From: Martyn White
Sent: 26 July 2019 15:06
To: Planning.Responses <Planning.Responses@arun.gov.uk>
Cc: Amber Willard <Amber.Willard@arun.gov.uk>
Subject: AW/139/19

AW/139/19

The application is for a single storey rear extension and single storey front extensions to a detached property in the Craigweil House Conservation Area. It is noted that it is an amendment to previously approved application.

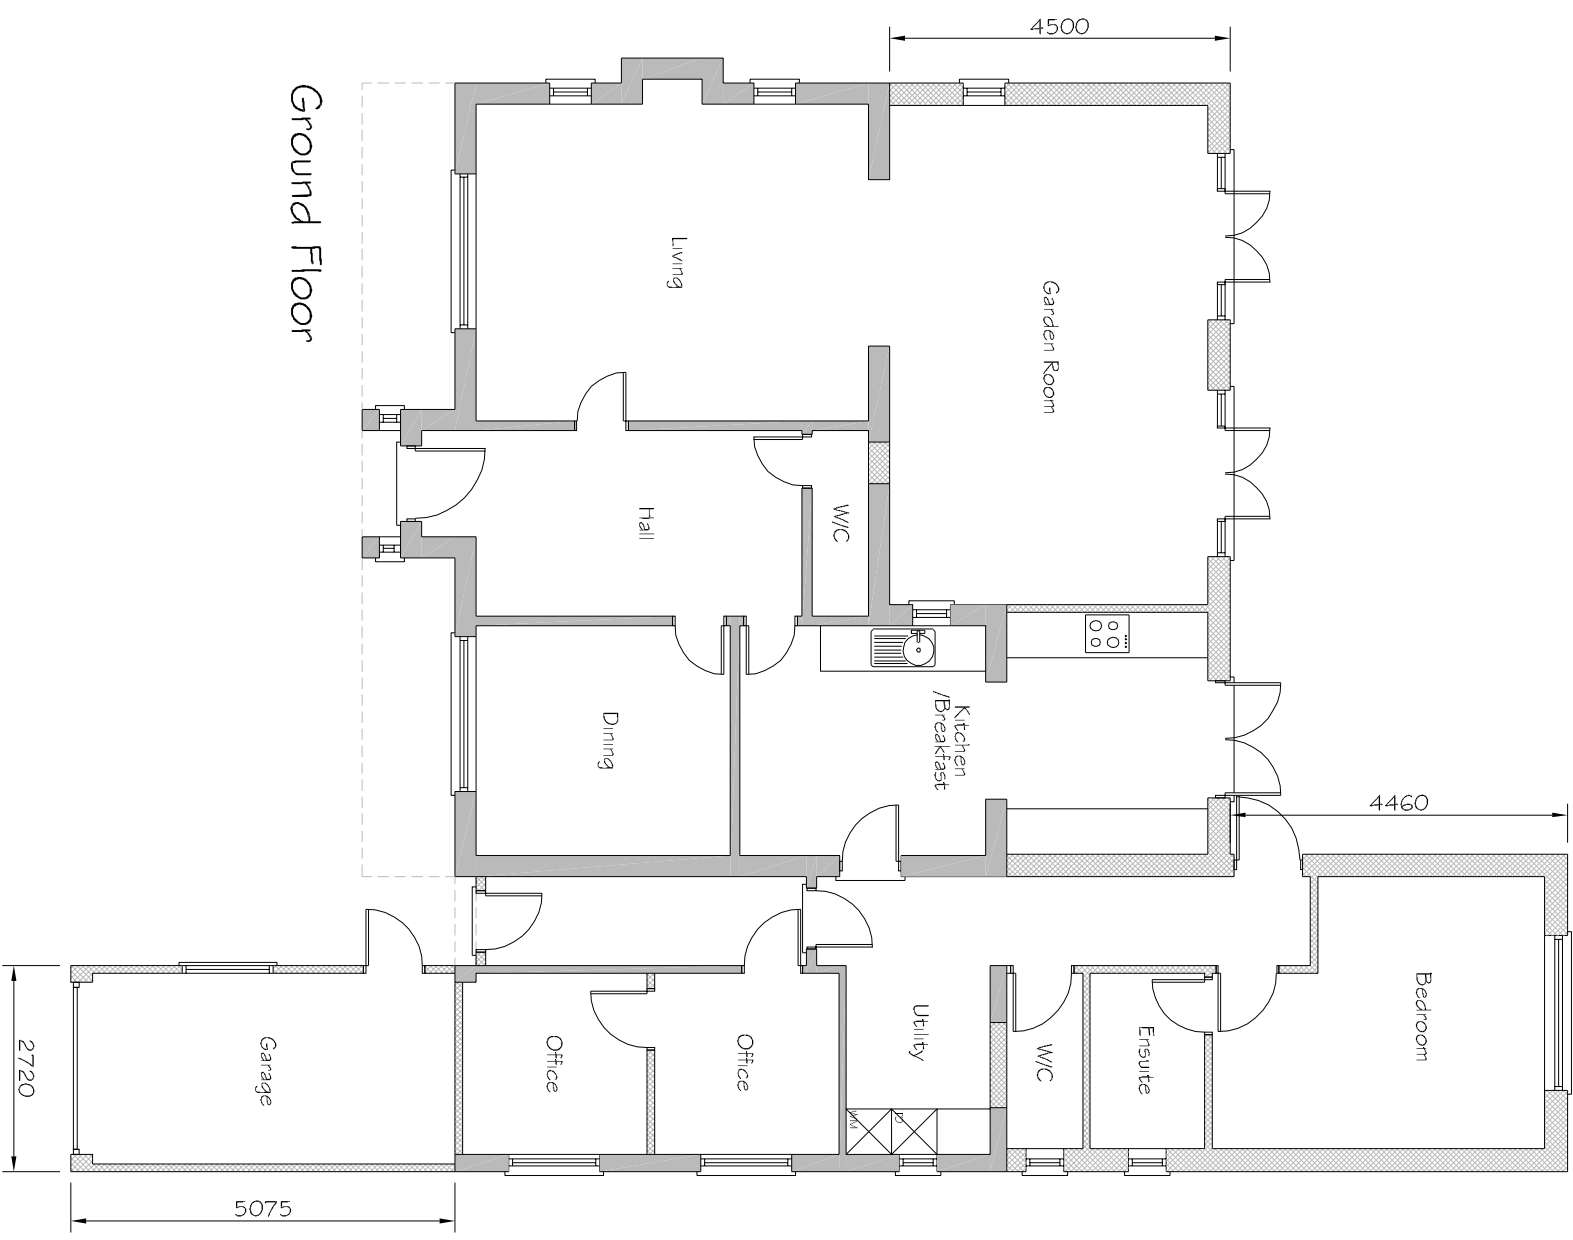
However, the front extension is considered to be problematical. It stretches substantially further forward than the existing established building line and would look incongruous in the street-scene of this part of the conservation area. This element of the application would therefore be considered to cause less than substantial harm in accordance with paragraph 196 of the NPPF (2018). As such, you will also need to consider the public benefits that the development may achieve as part of your assessment of the application, along with the contents of section 72 of the Planning (Listed Buildings and Conservation Areas) Act 1990 (as amended).
